Application No: EP/67/20/PL
Site Address: Land adjacent to 45 The Ridings East Preston BN16 2TW
Description of works: 1 No. detached house & formation of associated new access.

Thank you for your internet representation made on 8th July 2020 which has been recorded as an objection with the comments as follows:

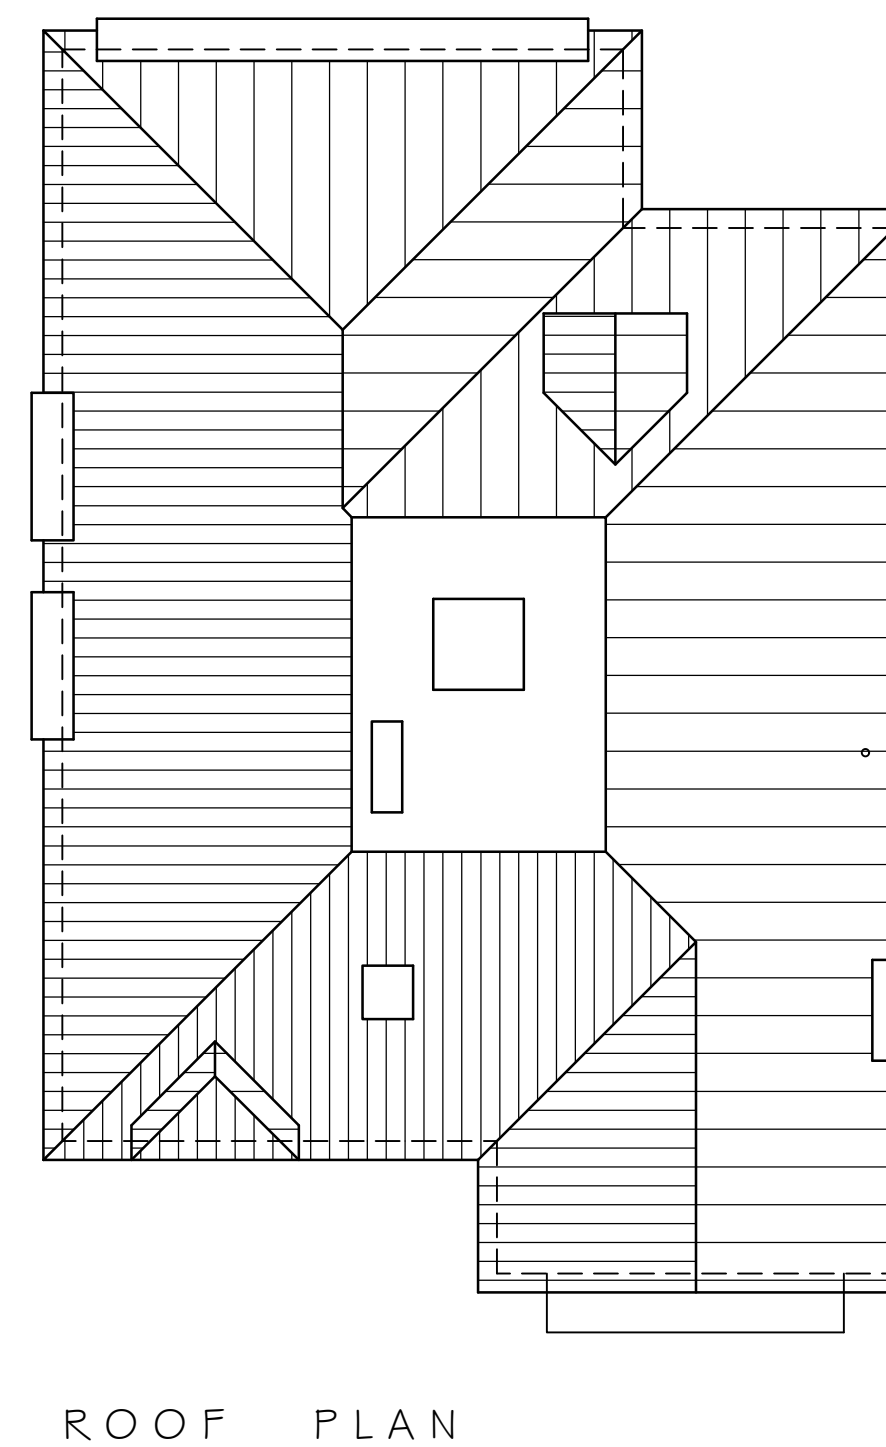
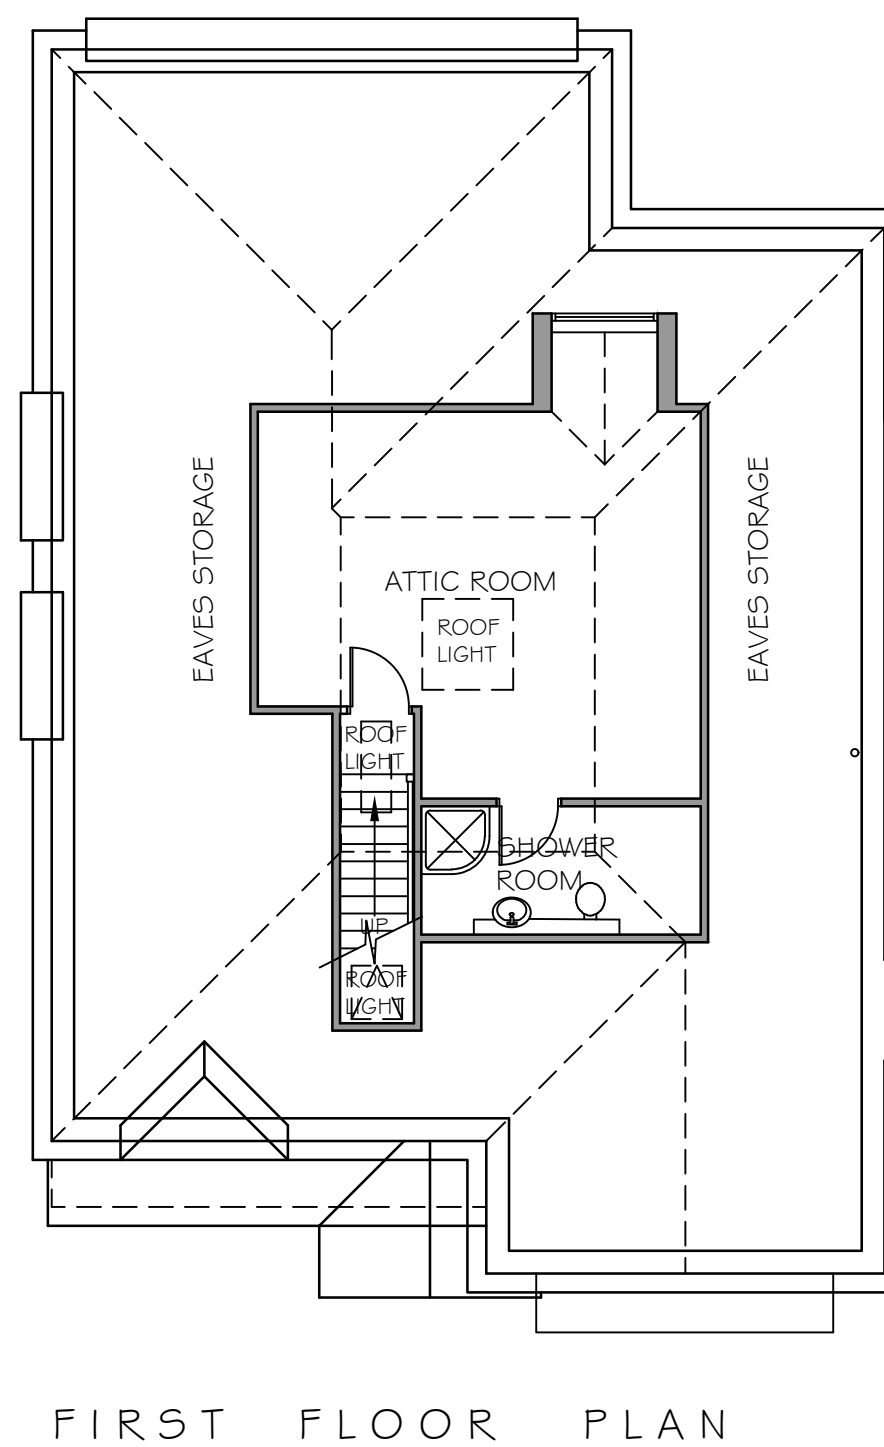
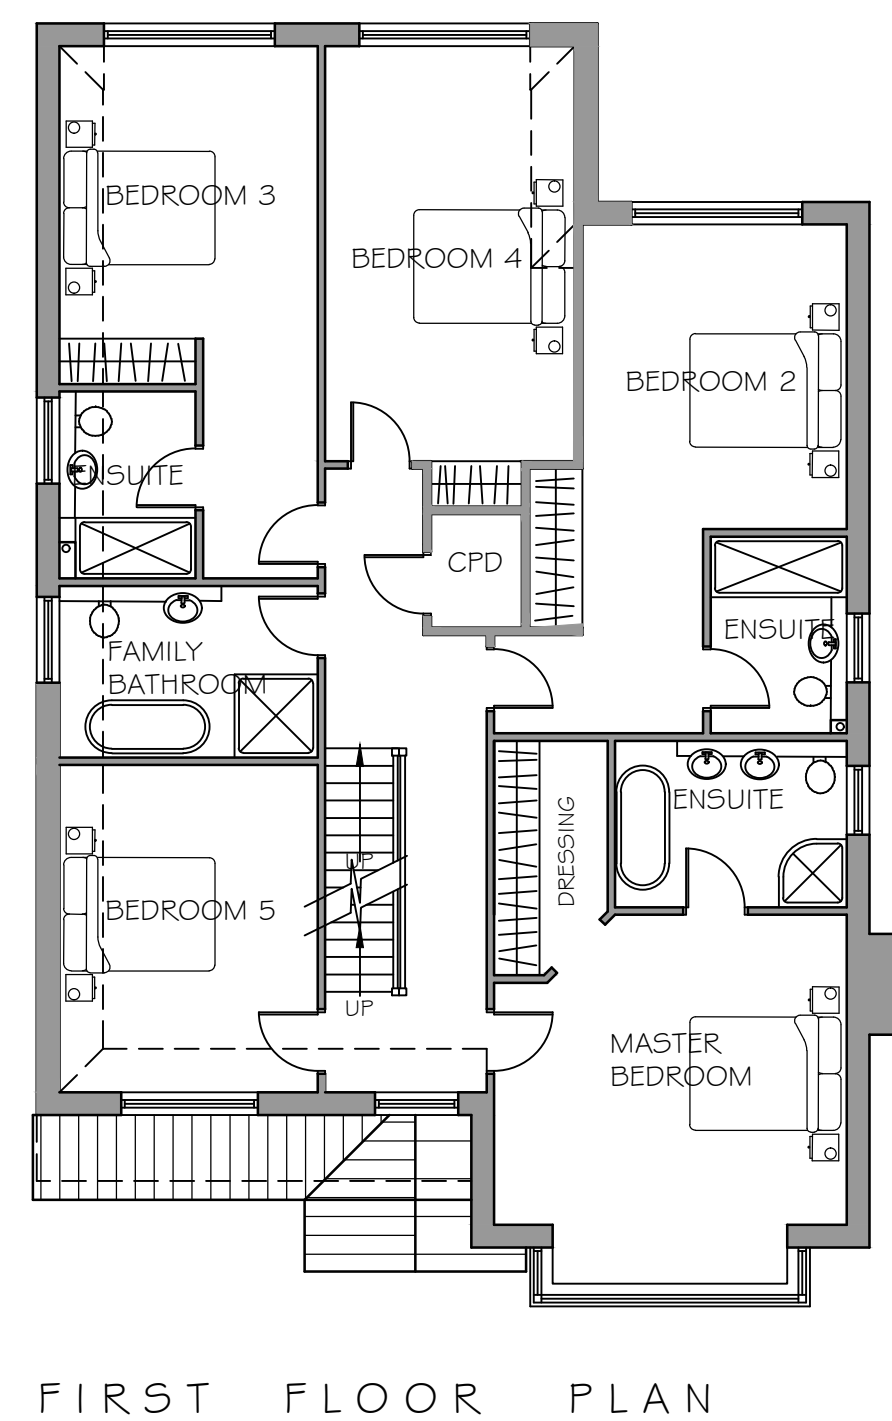
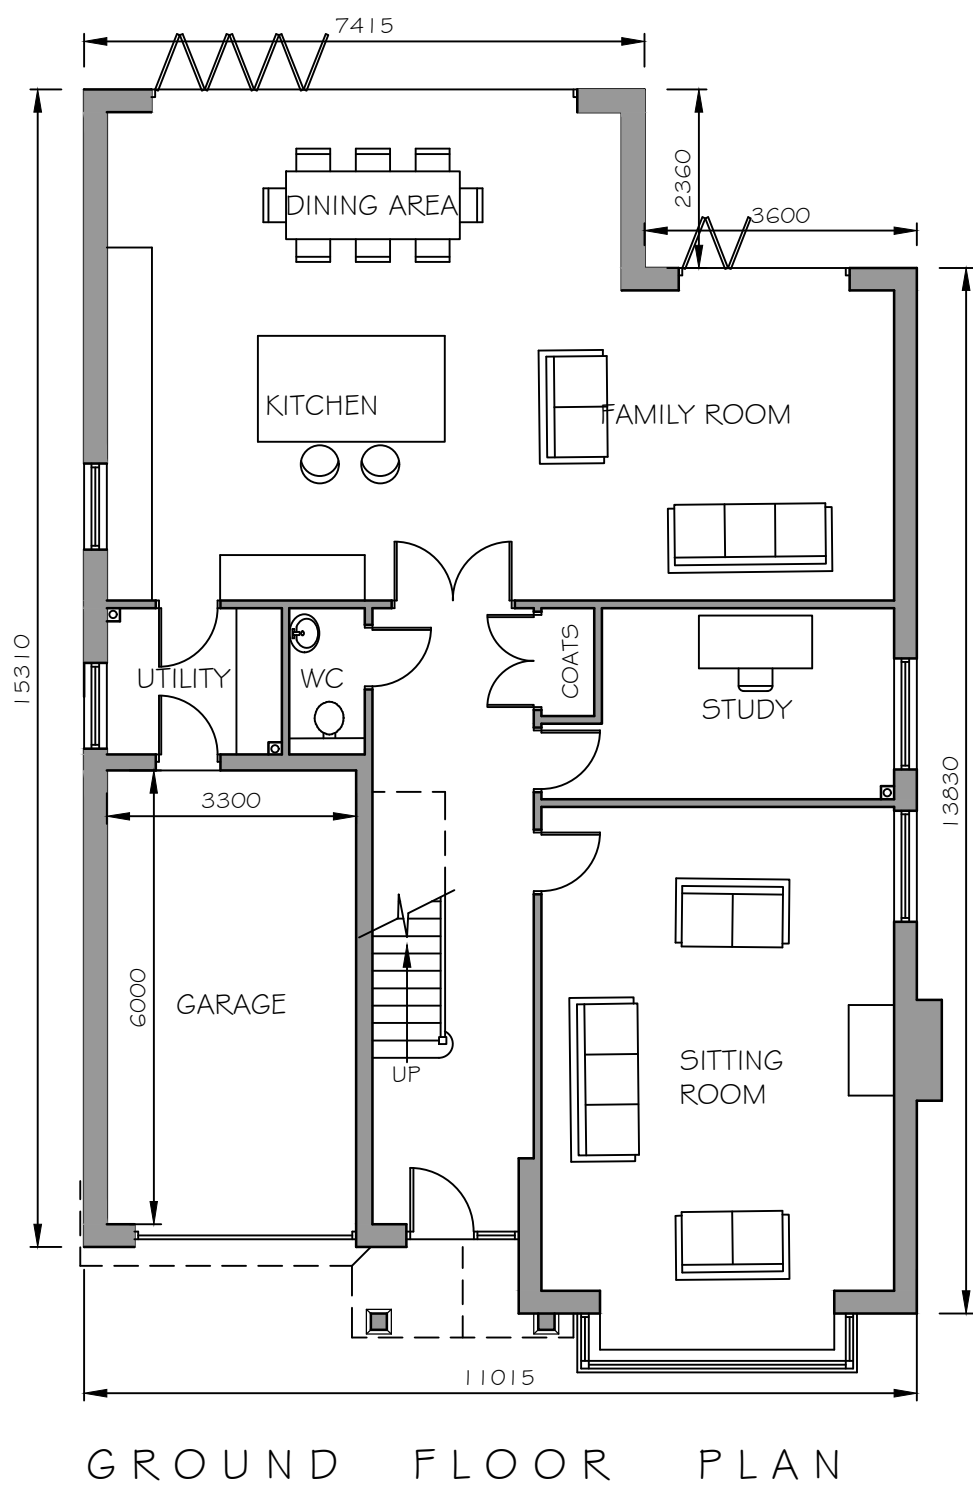
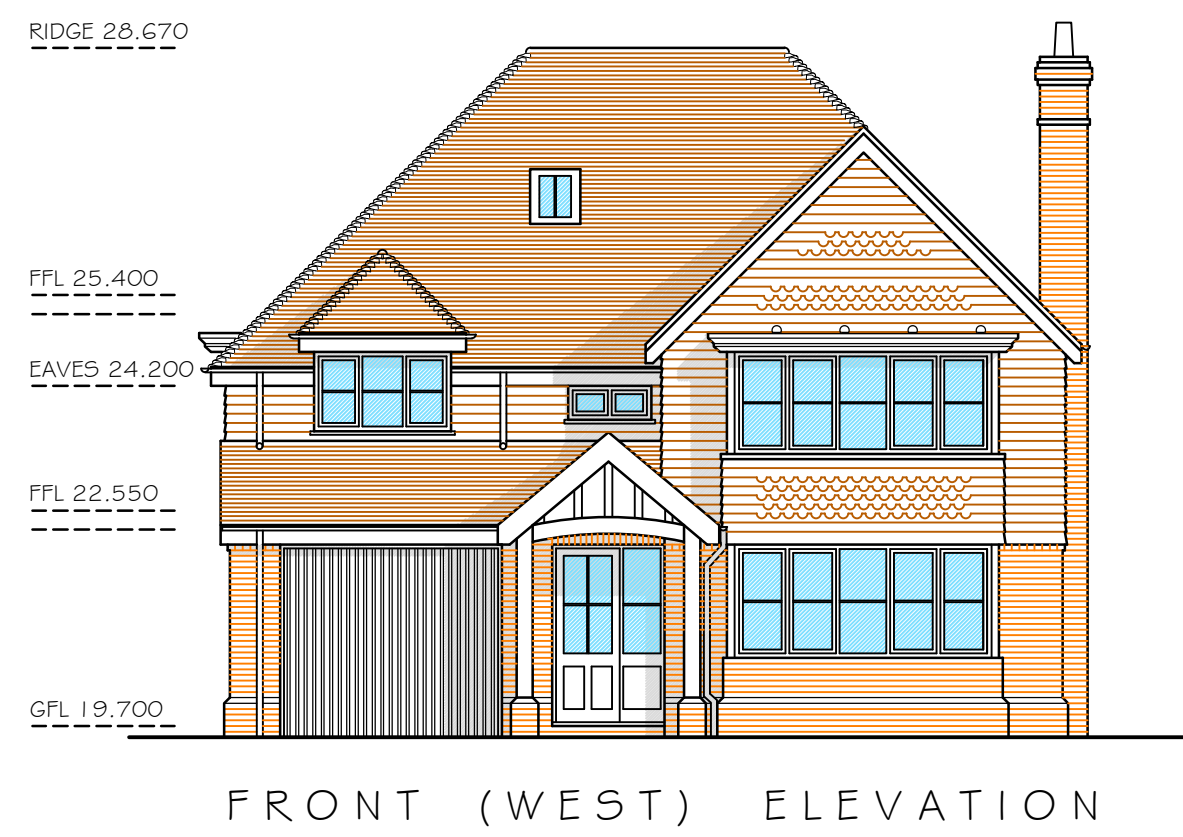
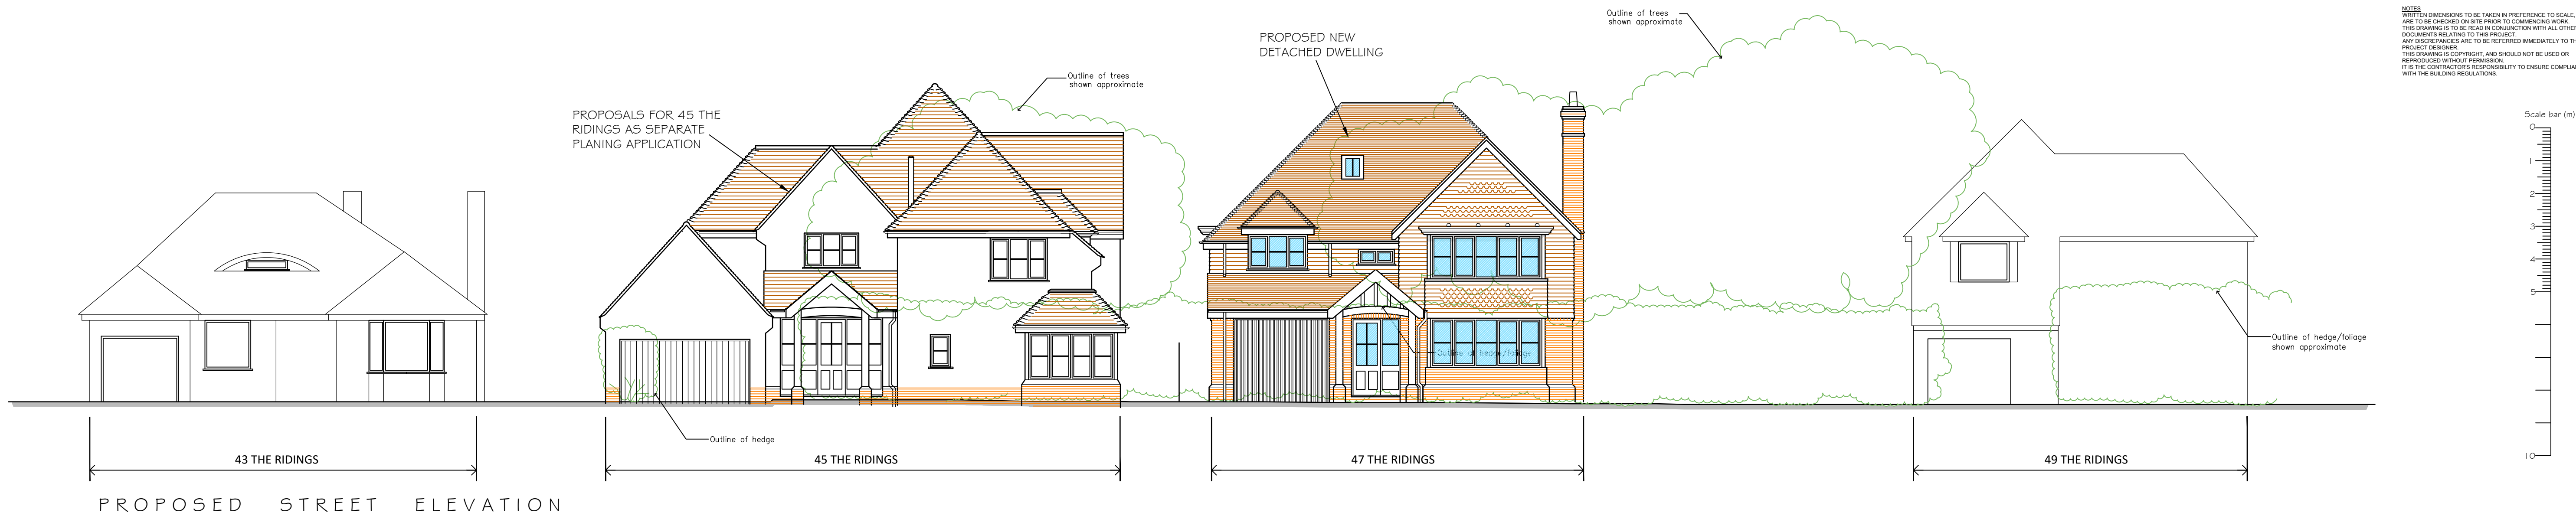
Overall, the property may be a bit big for its location within the plot and streetscene. The committee was also concerned about the exact number of storeys this property will be. Drawing 935/P01B includes two First Floor Plans, which is physically impossible. The committee considered the proposed design would be contrary to Policy 1 of the East Preston Neighbourhood Plan, paragraph 4.14 of which states, New or altered buildings that exceed two stories in height will rarely be acceptable. It is clear from the concerns raised by neighbouring properties the roofspace is seen as a separate storey by those most closely affected.
